Application Reference: WA/28/26/DOC Site Name: Stoneybrook Farm Eastergate Lane Walberton BN18 0BA	Initial Issue Date: 30/04/2026 Issue Date: 30/04/2026 Reviewer Reference: ADC/EXT5/AF
---	--

Condition 3: **Objection**

ADC Drainage Comments	Designer Response			
Date:	30/04/2026	03/06/206			
Condition Number: 3					
Comment Number					
1.	Designs, sizing and details for the proposed rainwater harvesting should be provided.	1,000ltr water tank located to the rear of the building to pick up rainwater for reuse as part of the business operation.			
2.	Greenfield runoff calculations should be provided for the drained area.	Greenfield calculations attached. For the whole drained site an area of 0.201ha has been used which generates 0.5l/s.			
3.	The use of the pond for interception drainage is not suitable as the top water level would be at the overflow level during winter.	The groundwater level is recorded at 10.333m, the outfall level is 10.383m allowing for 50mm of be retained in the pond and allowed to infiltrate through the sides. The interception volume will be 12.5m ³ .

Section D-D
Scale H 1:250
V 1:50

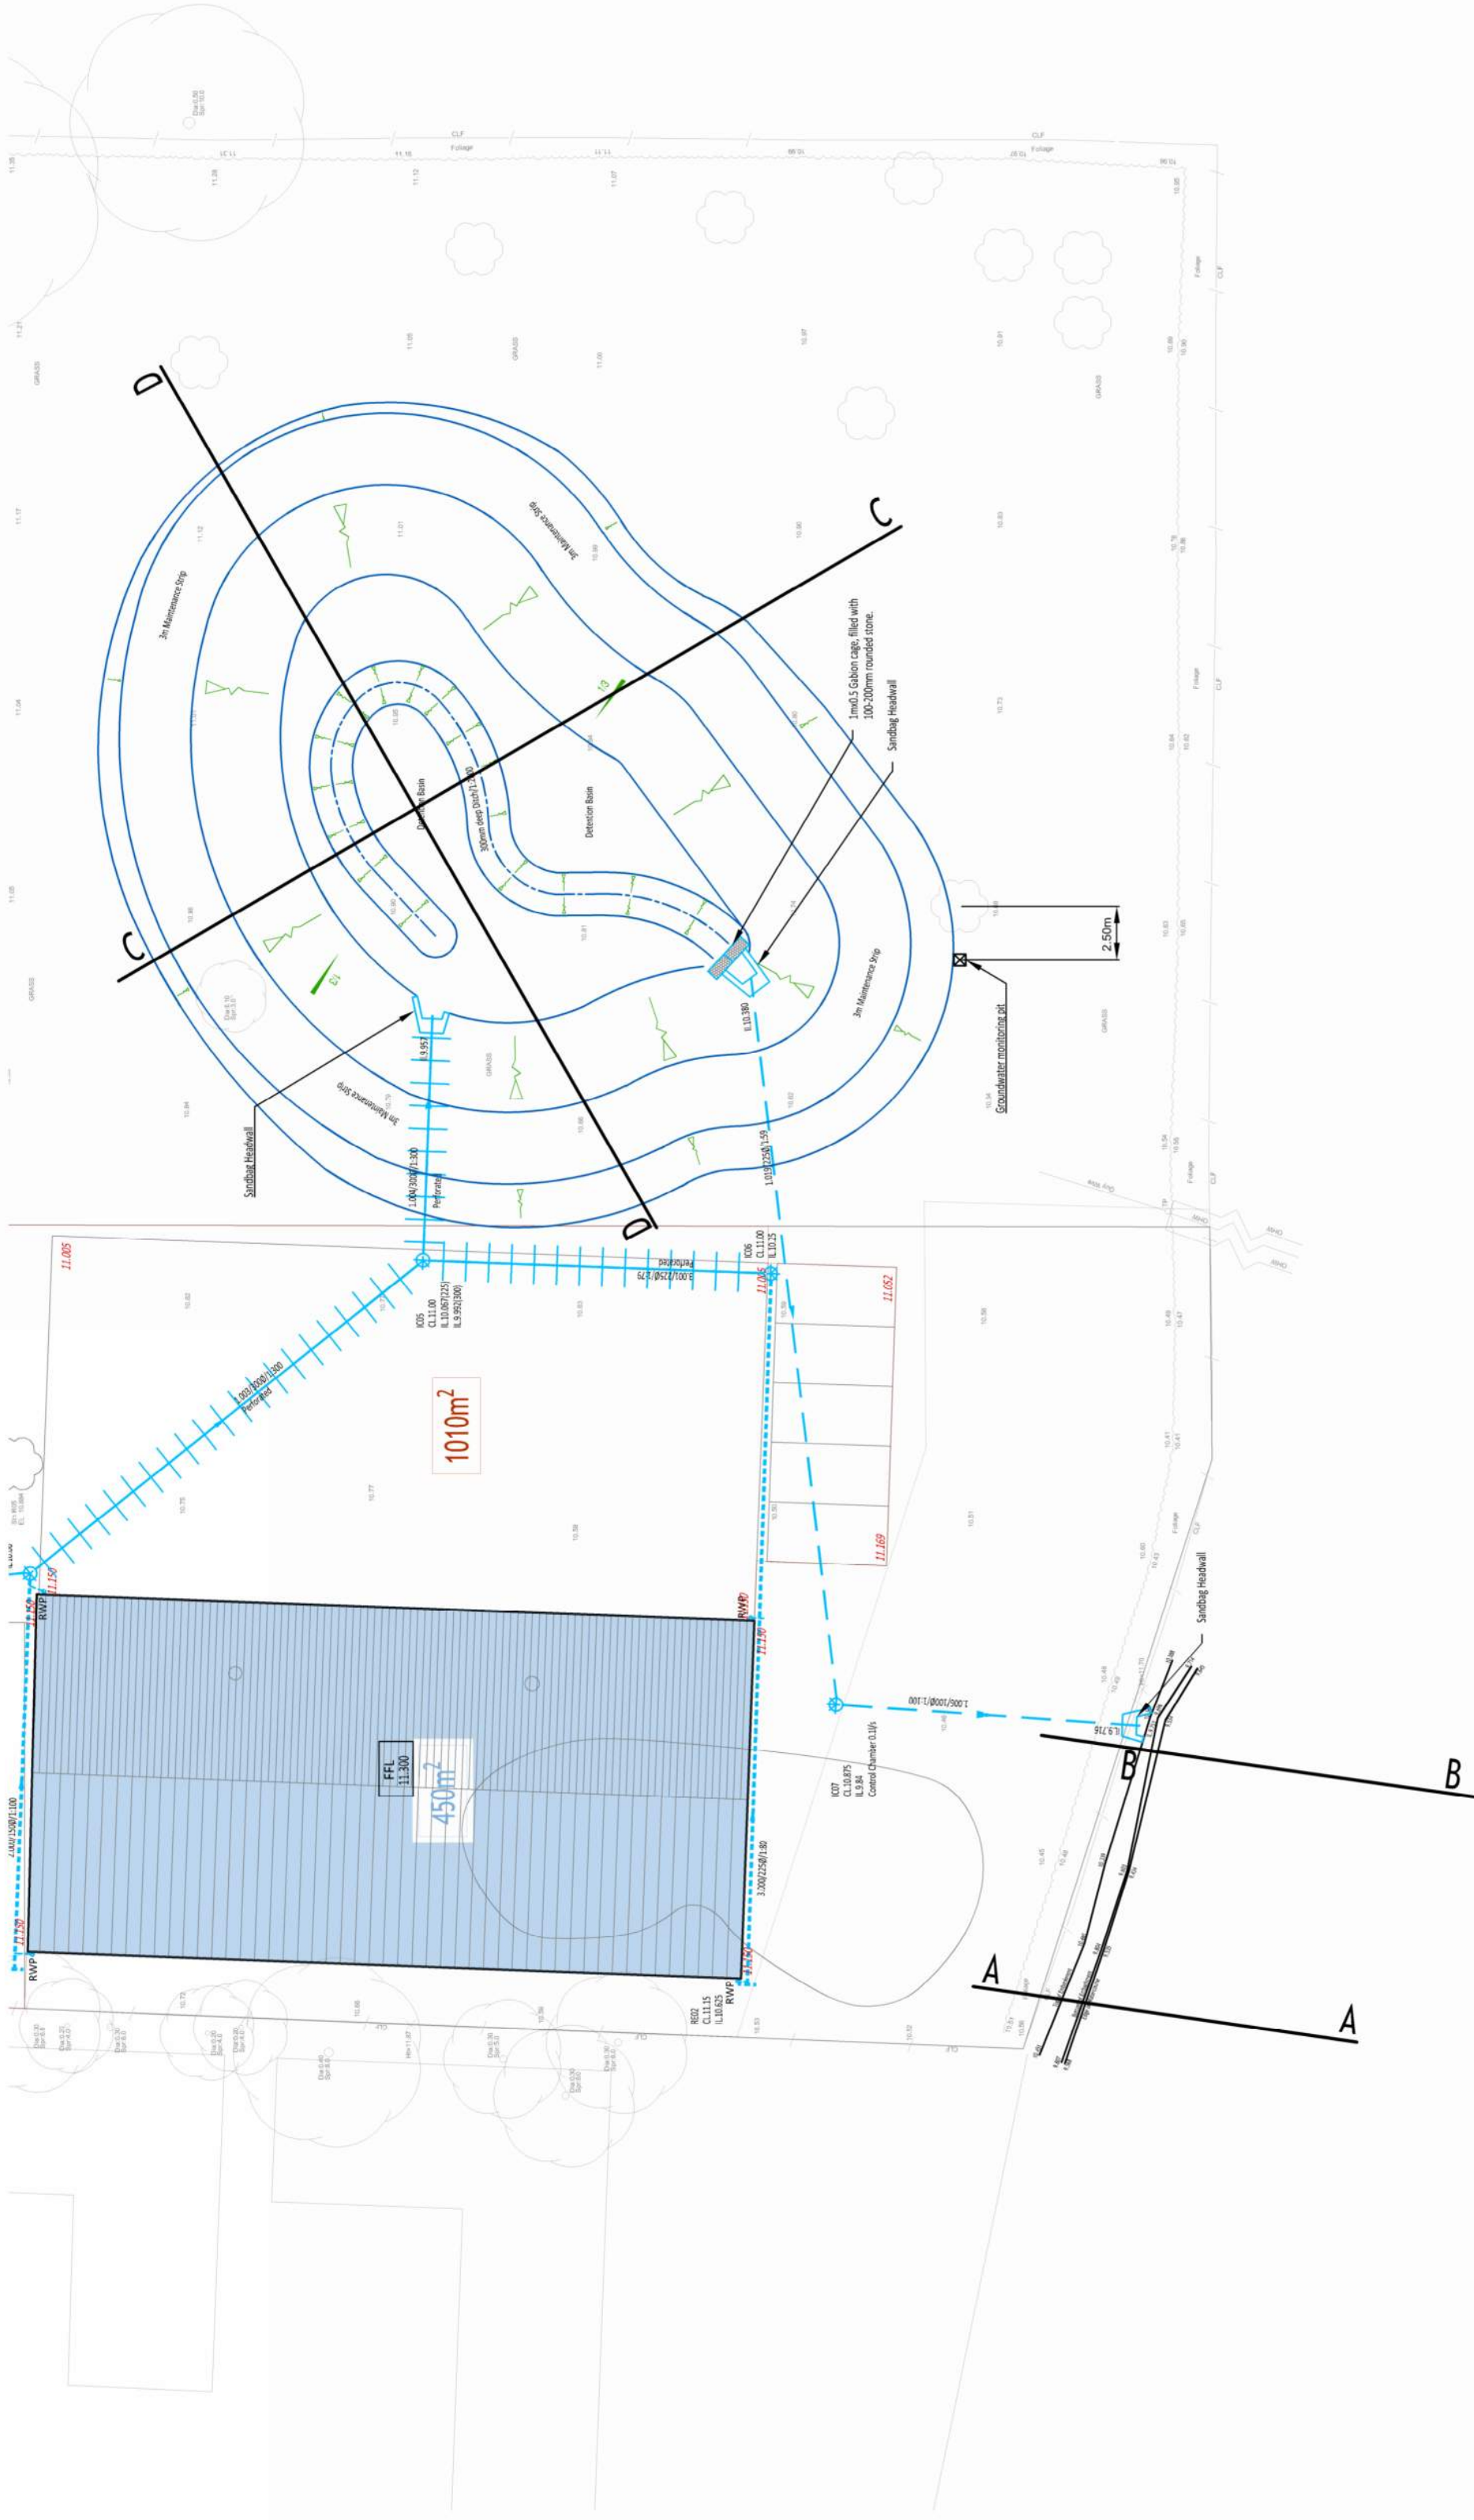
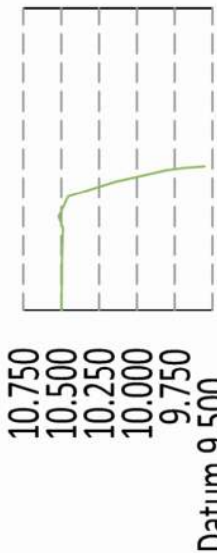
periods where no groundwater is present			
6.	Construction details should be provided for the basin construction and liner.	Details have been provided.

Front Elevation - Basin Headwalls

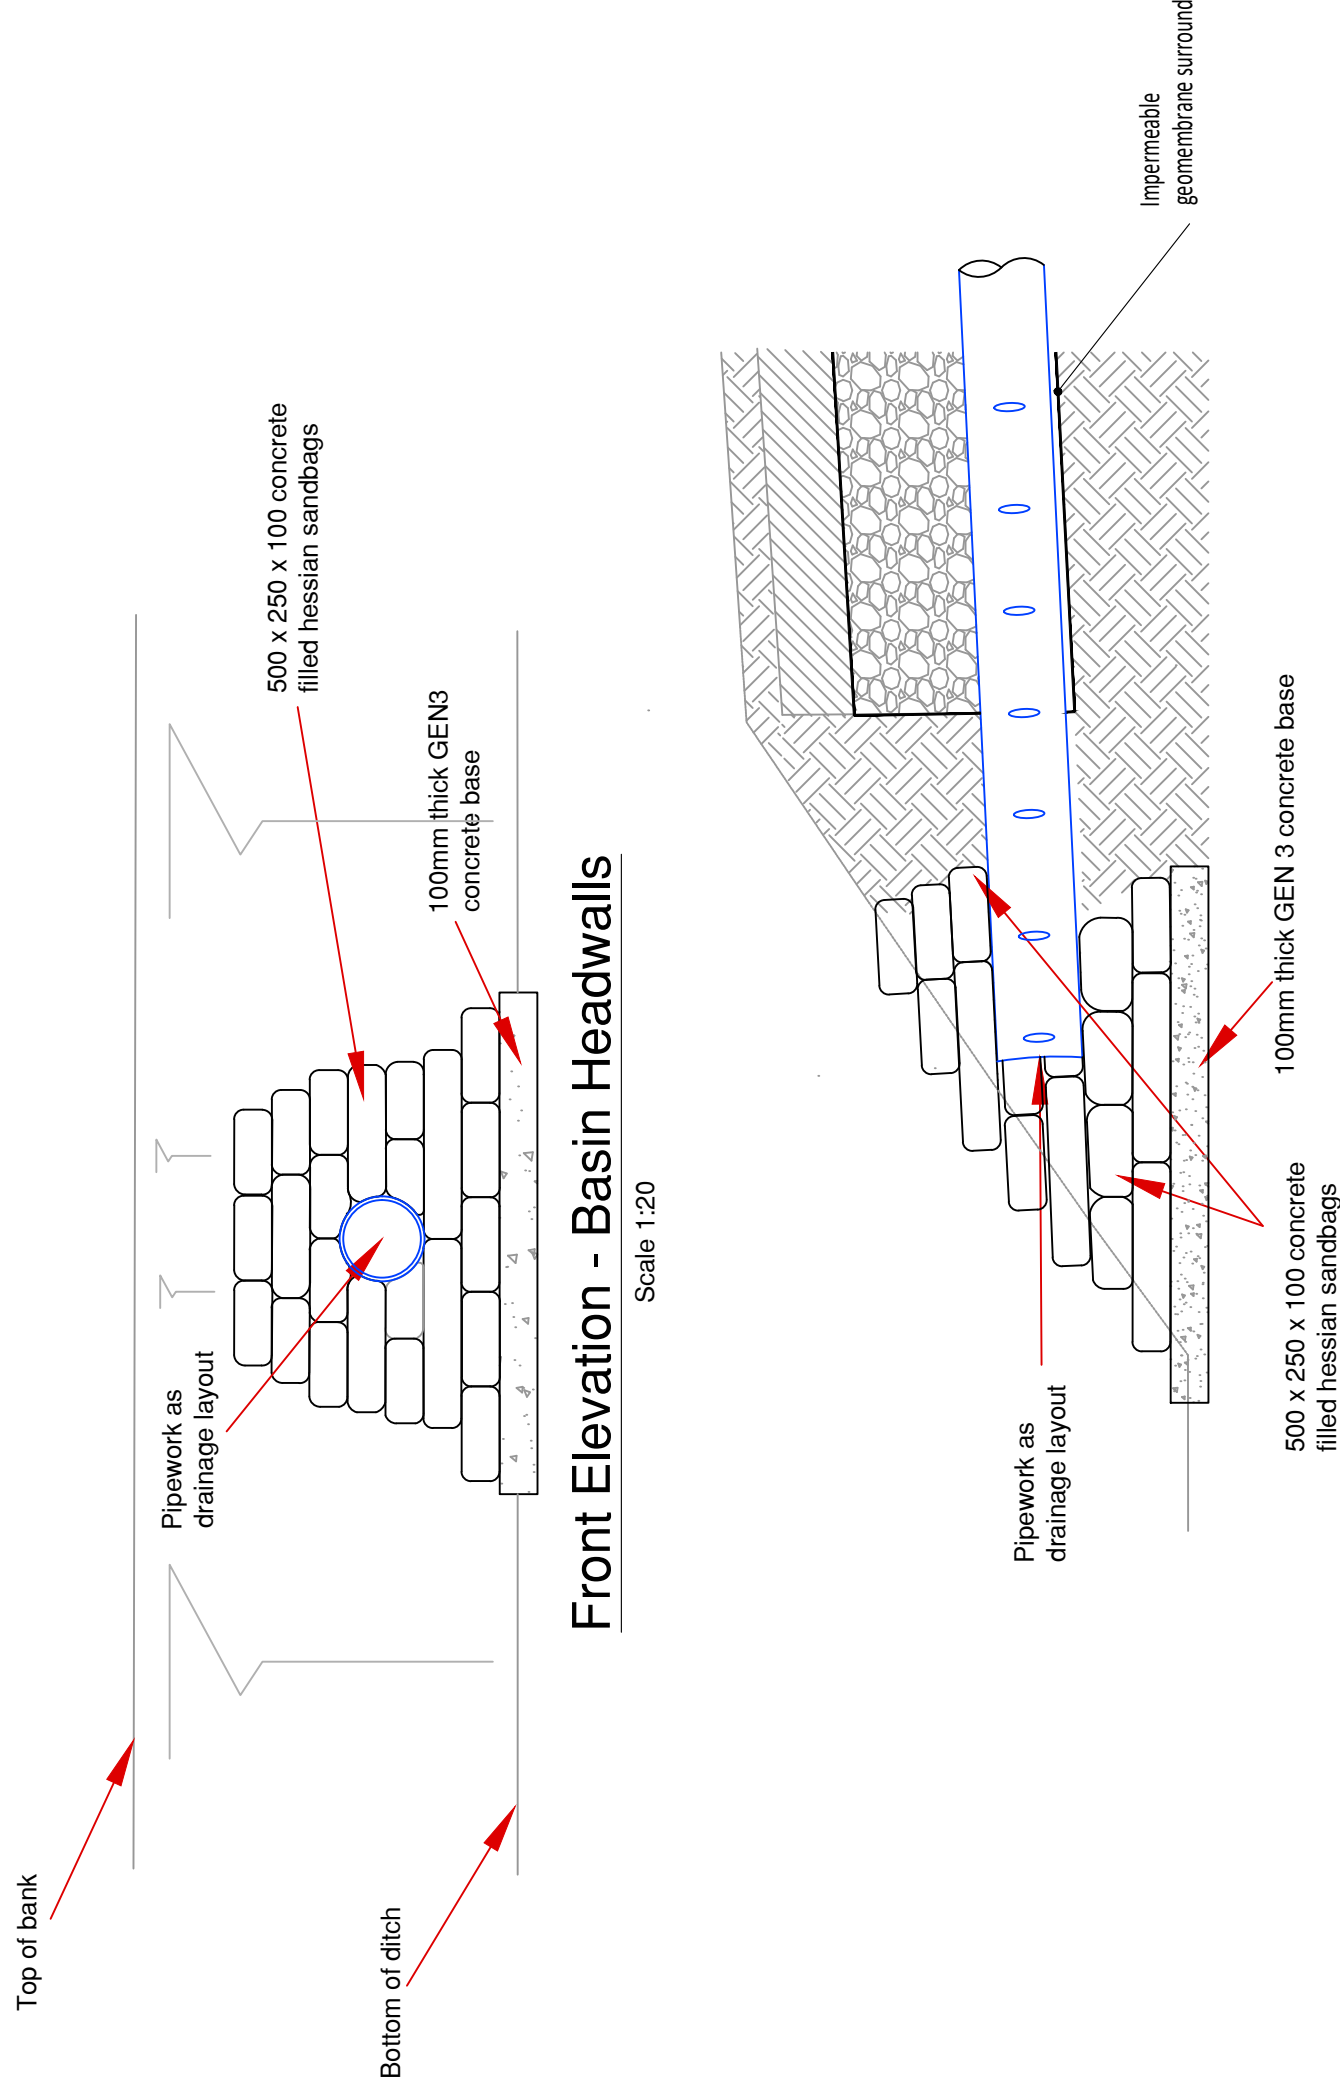
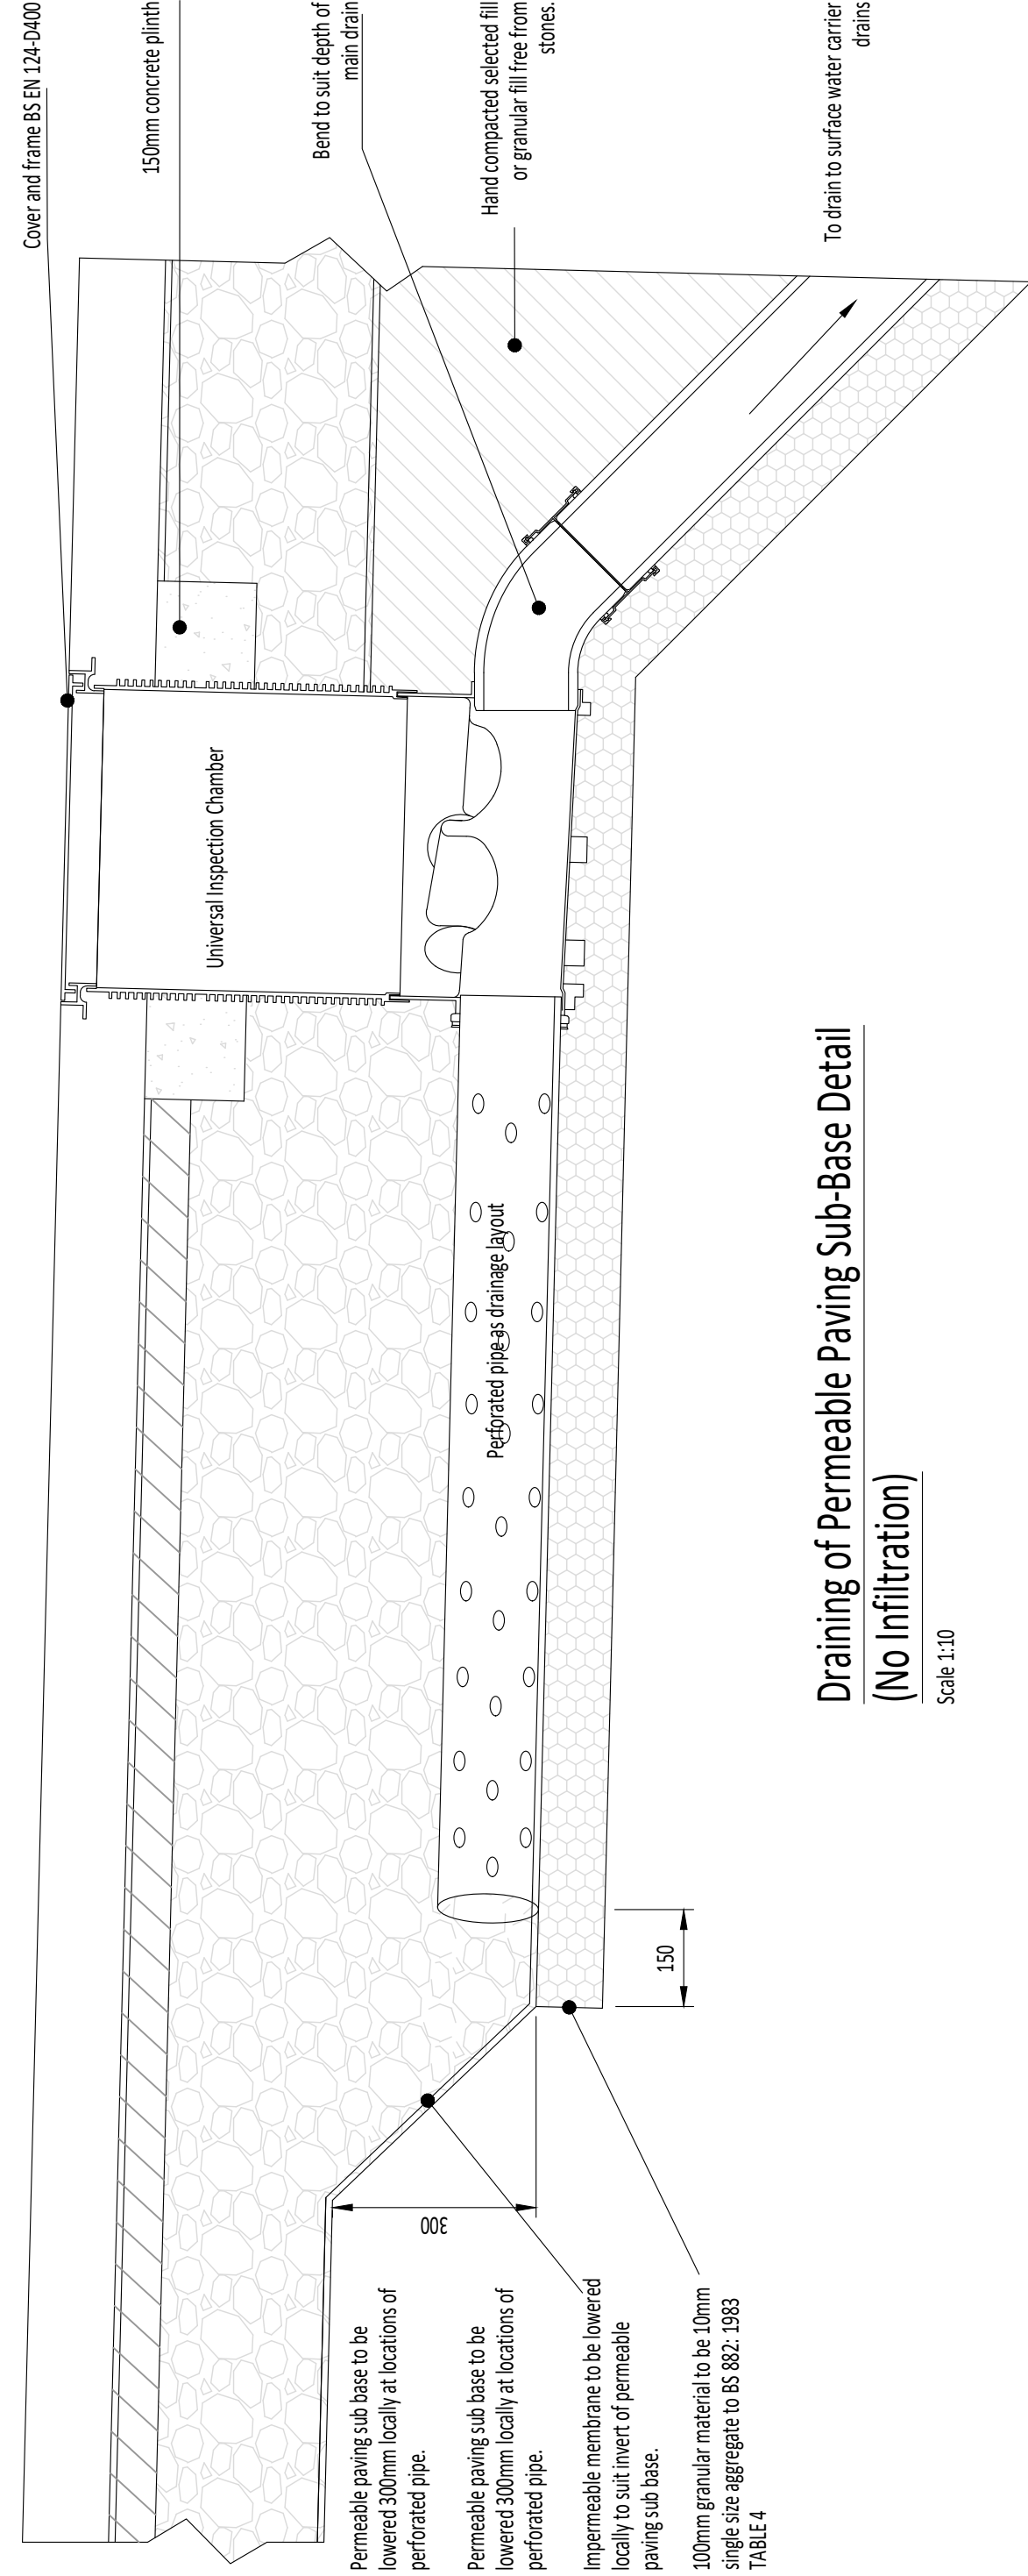
7.	Measures to mitigate blockage of the flow control device should be incorporated at the basin headwall and flow control chamber.	Gabion cage is proposed in front of the outlet headwall to provide a filter process and remove debris that could cause blockages. Construction detail provided.

Point 7 - Refer to Construction Detail
